DEVELOPMENT REVIEW BOARD--SPEED MEMO

CITY OF ALBUQUERQUE
PLANNING DEPARTMENT
Development Review Board
April 28, 2004
Comments

Re: Lot 3A2B, Block 1, Sunport Park Building Shell/SPBP

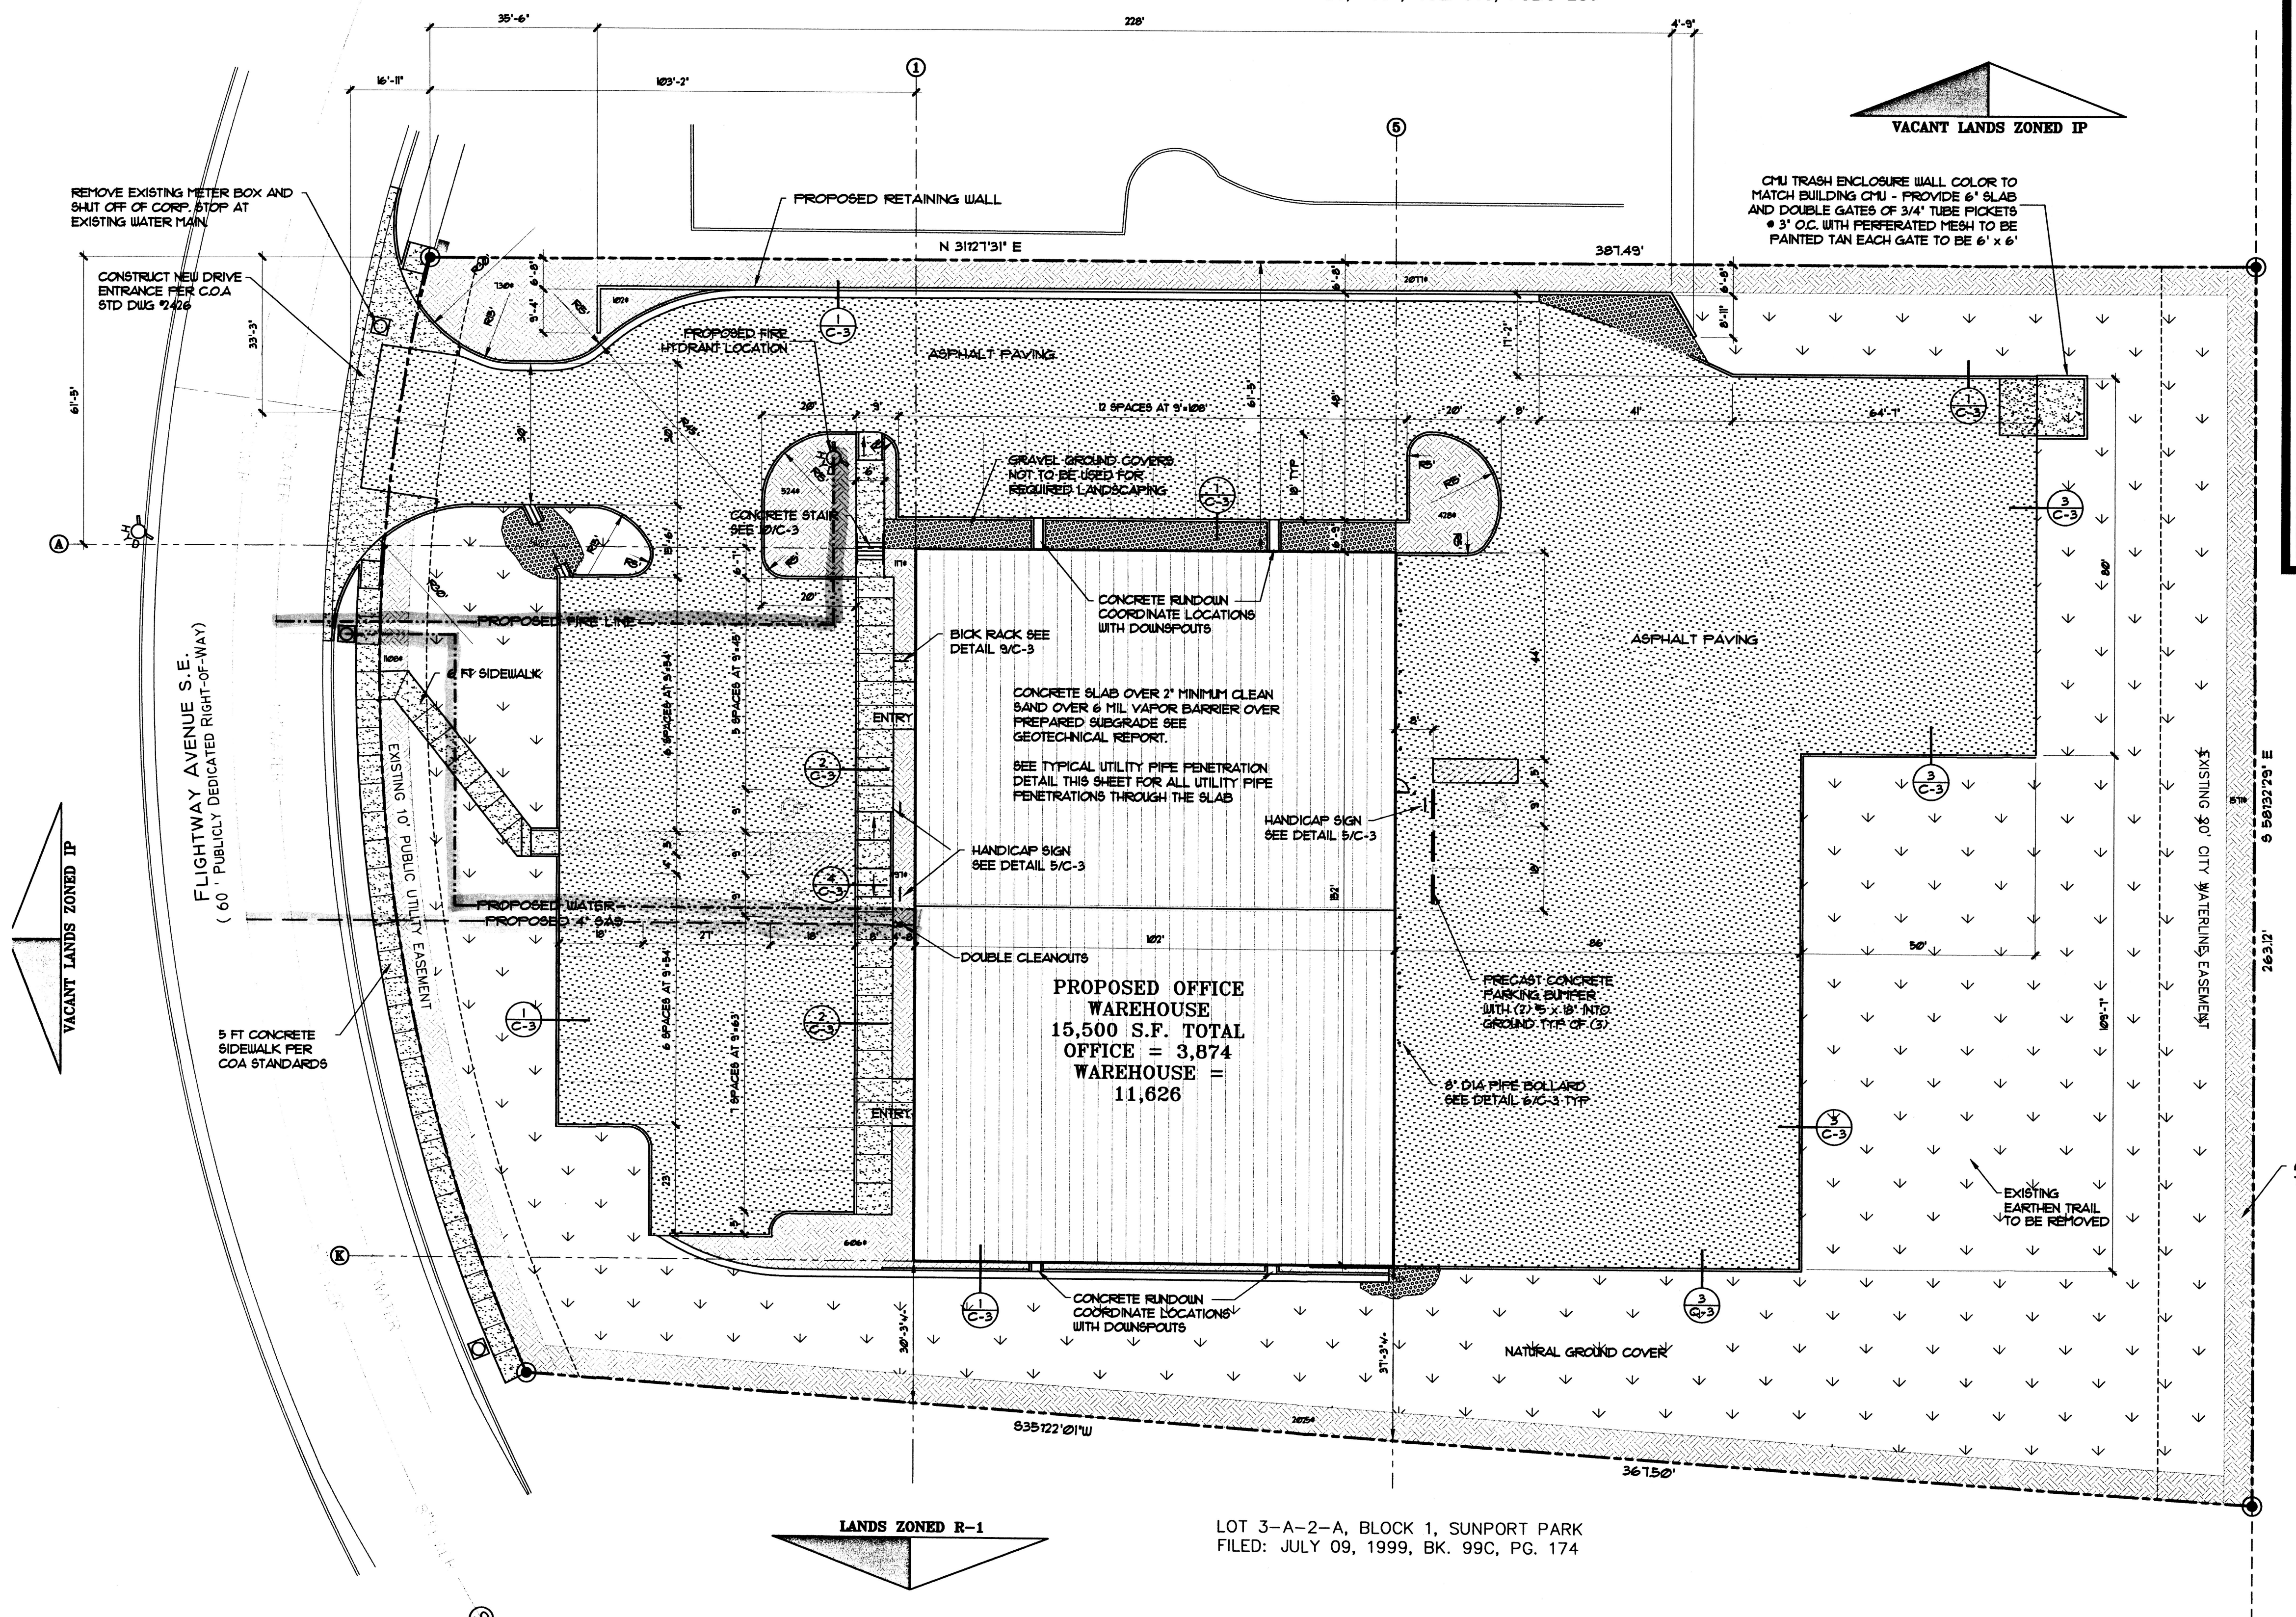
The site plan sheet's title should be "Site Development Plan for Building Permit". Be sure to use the current signature block available at our Front Counter. The signature block must be on the site plan sheet.

The proposed use & square footage of the building should be identified on the building footprint on the site plan per the SPBP Checklist.

The location, dimensions, materials, etc of any planned signage should be identified, including building mounted signage.

Is there any freestanding lighting? If so, these details should be on the plan as well.

Are there any walls or fences planned along the portion of the property facing Flightway Avenue? If so, the design, height, etc must be approved by the DRB Chairperson via a separate submittal.

A-2

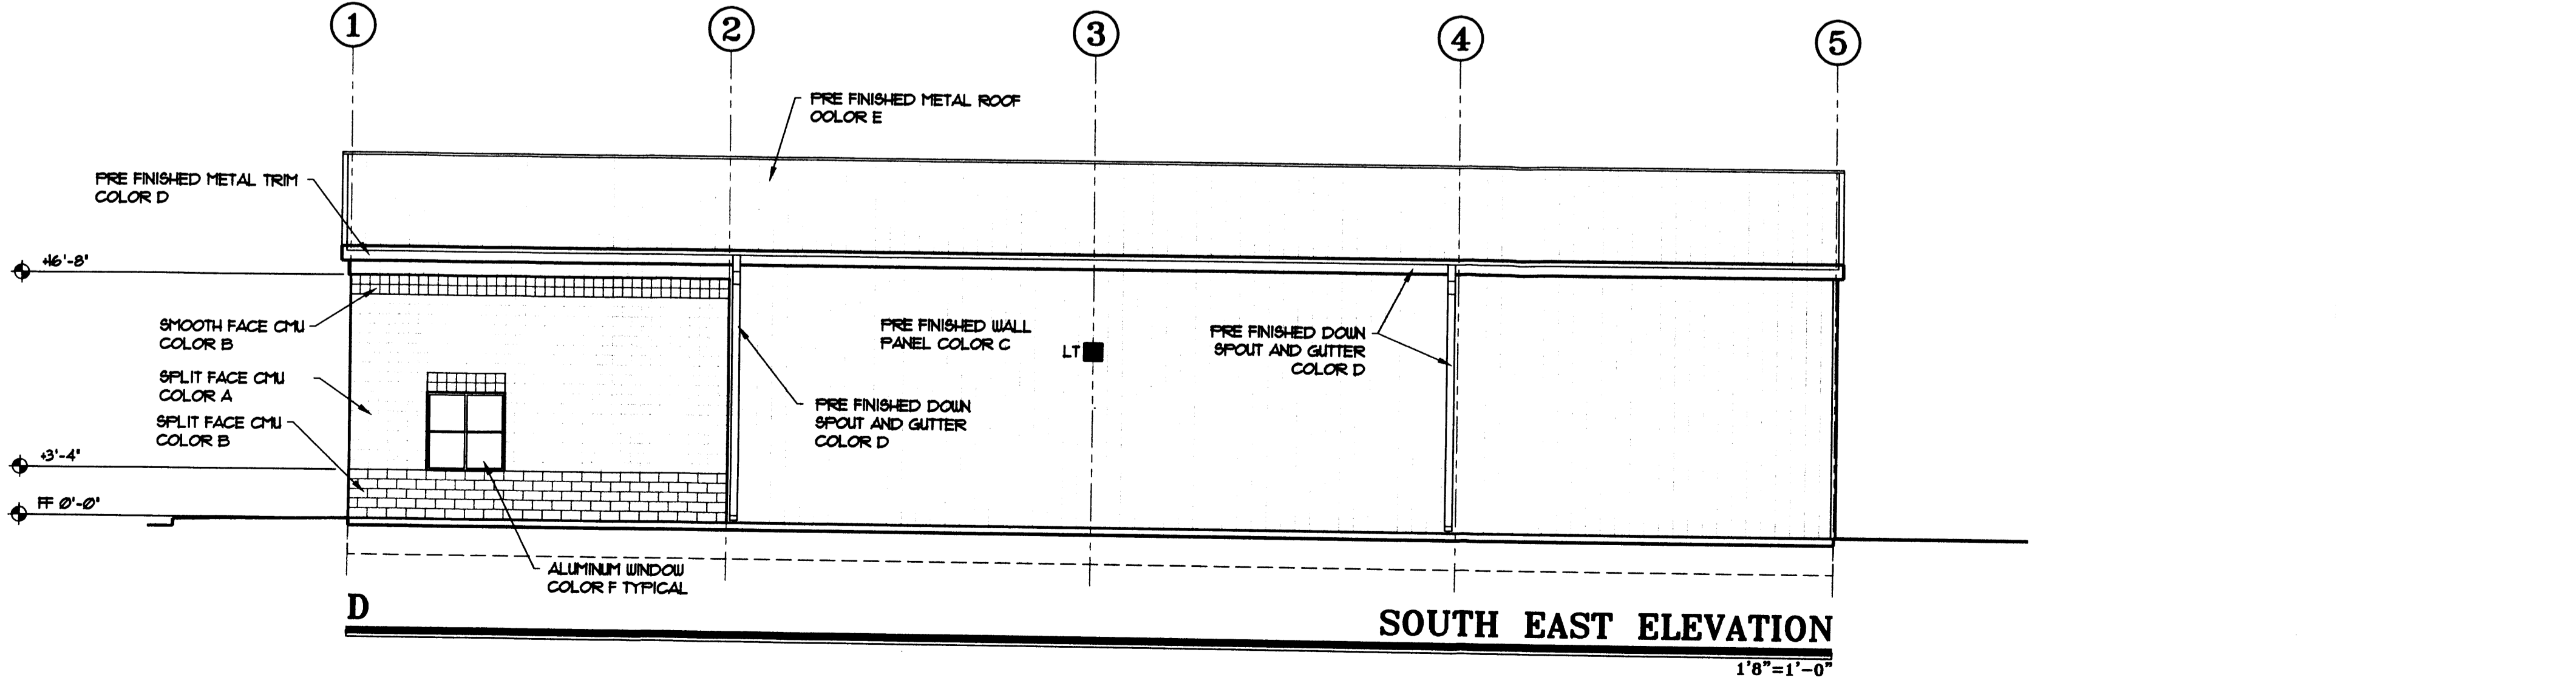
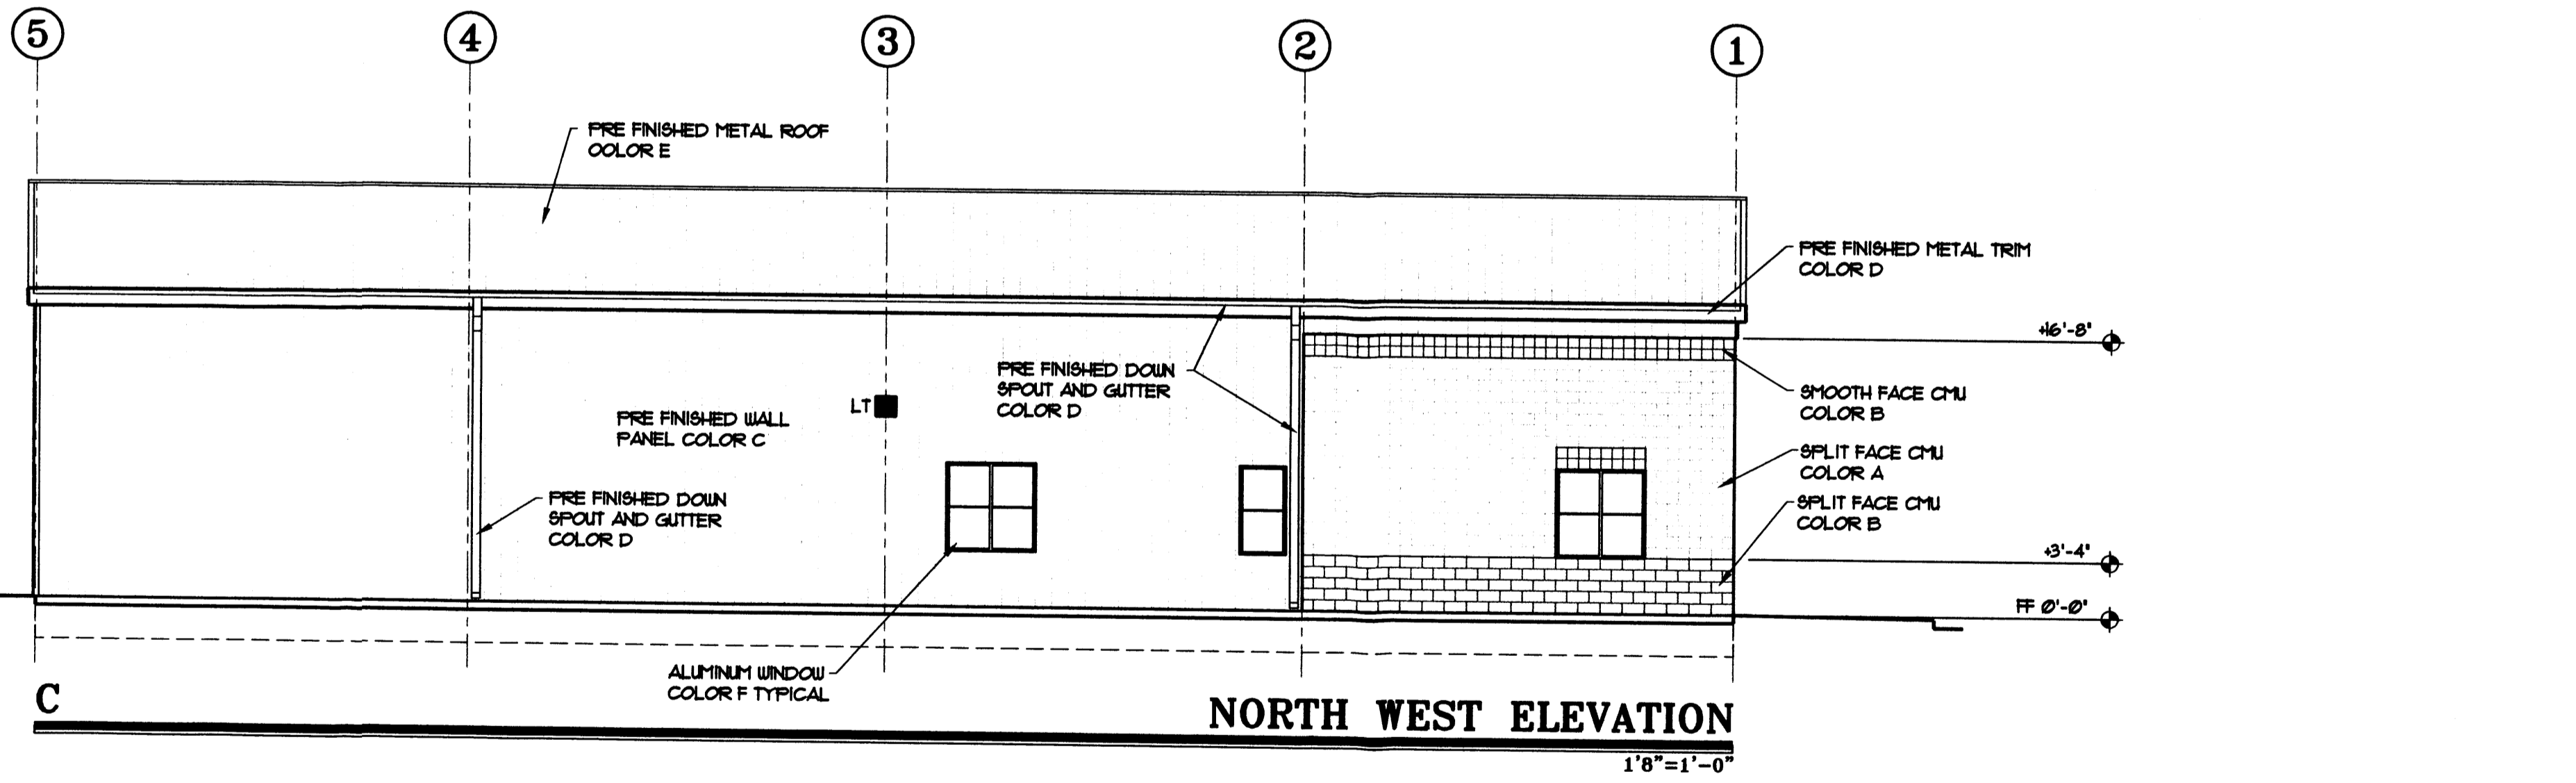
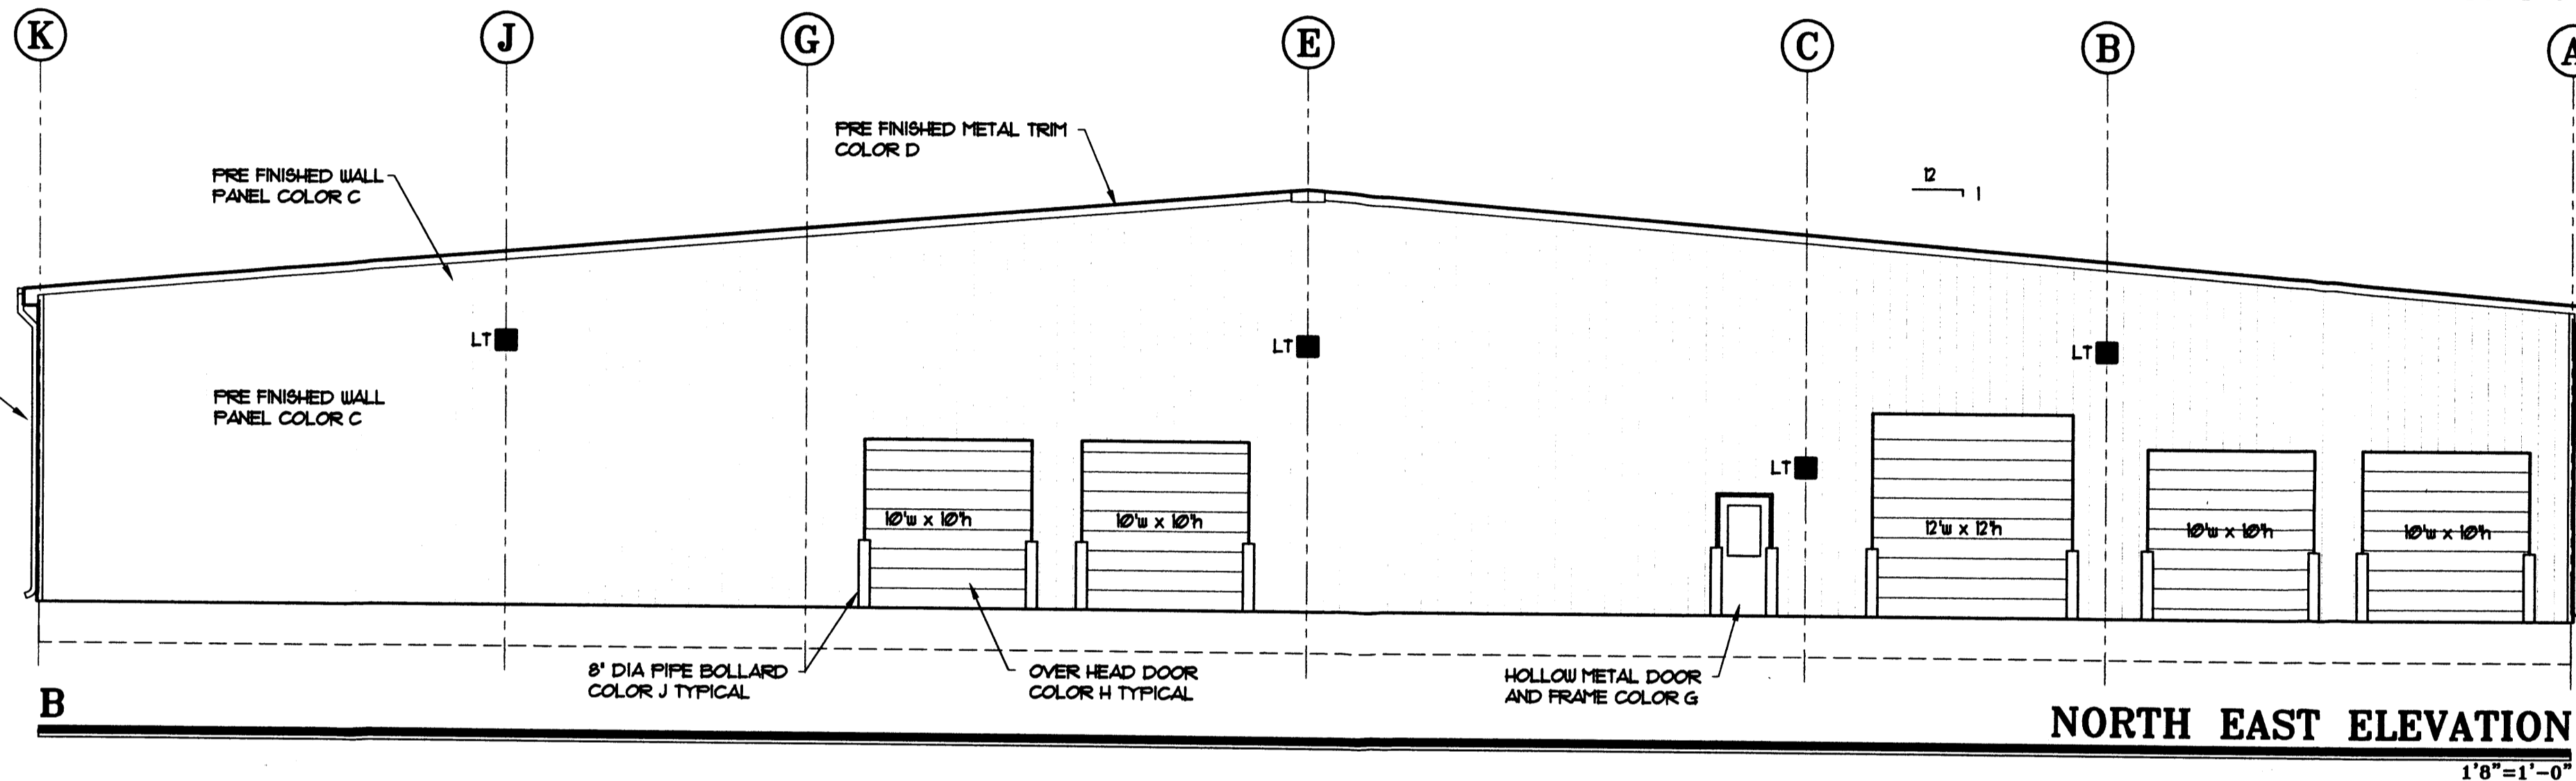
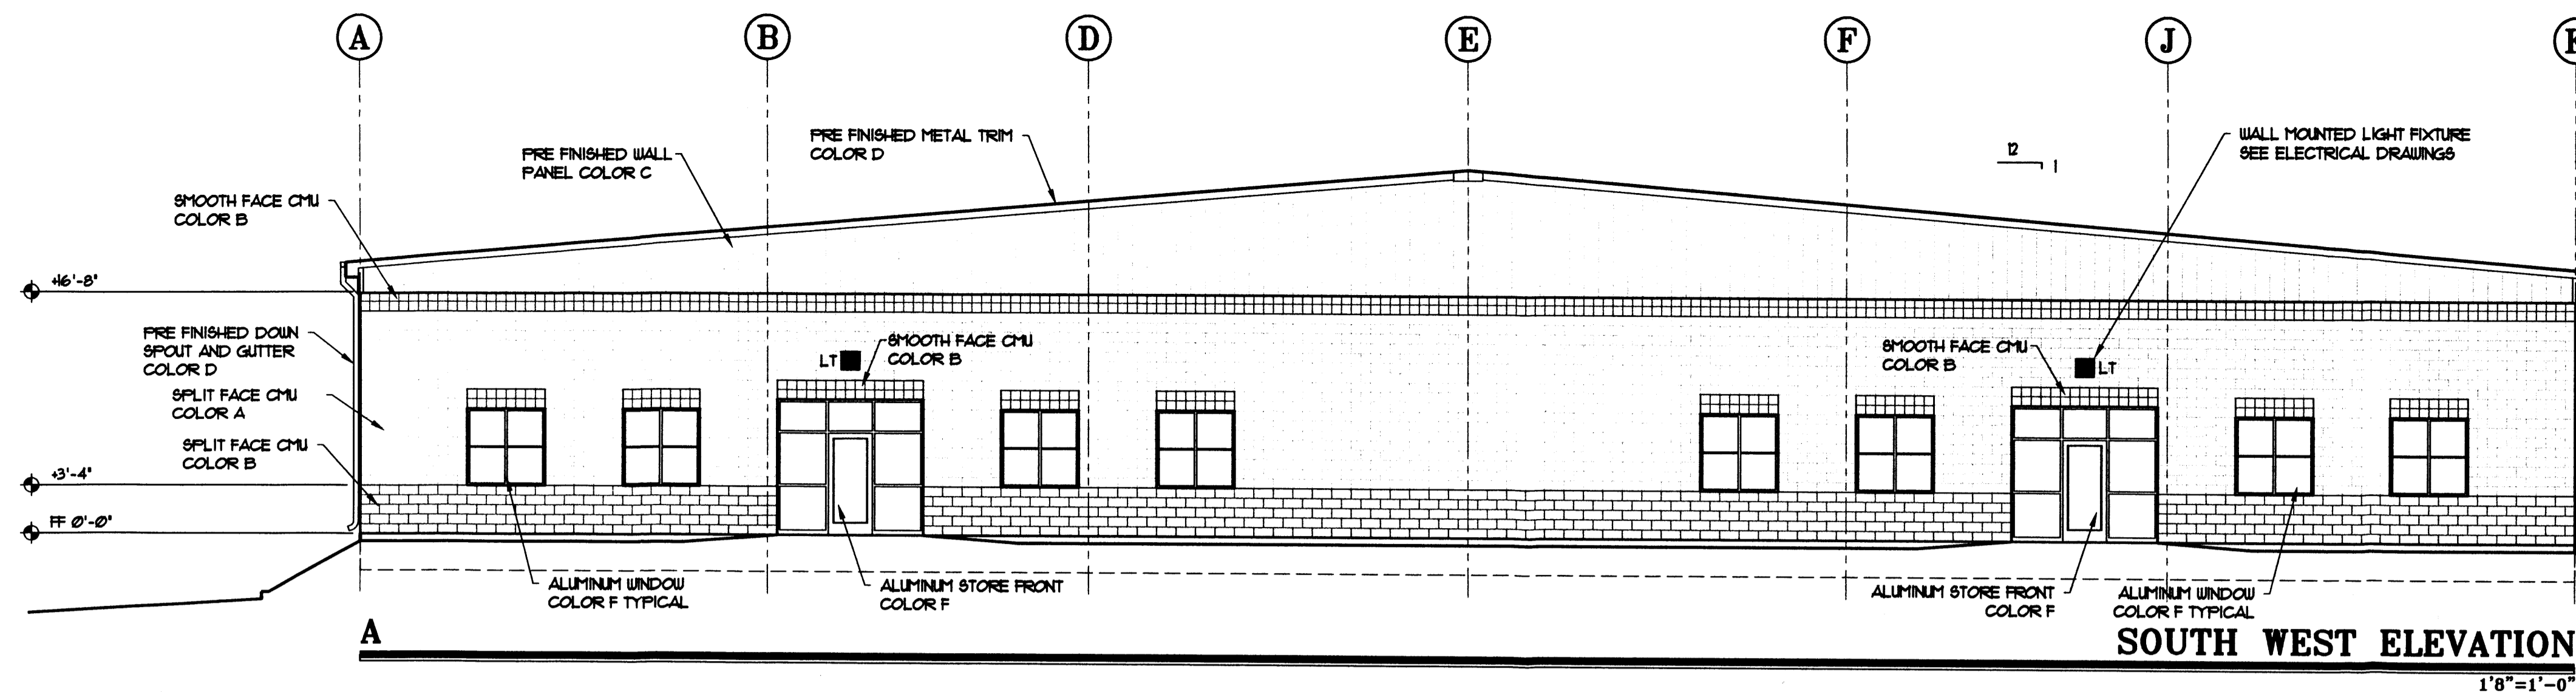
Building Elevations. The total height to the pitch of the roof is missing as is the total width of the building. The bar scale is missing from this sheet. The colors are not identified as required on the SPBP Checklist.
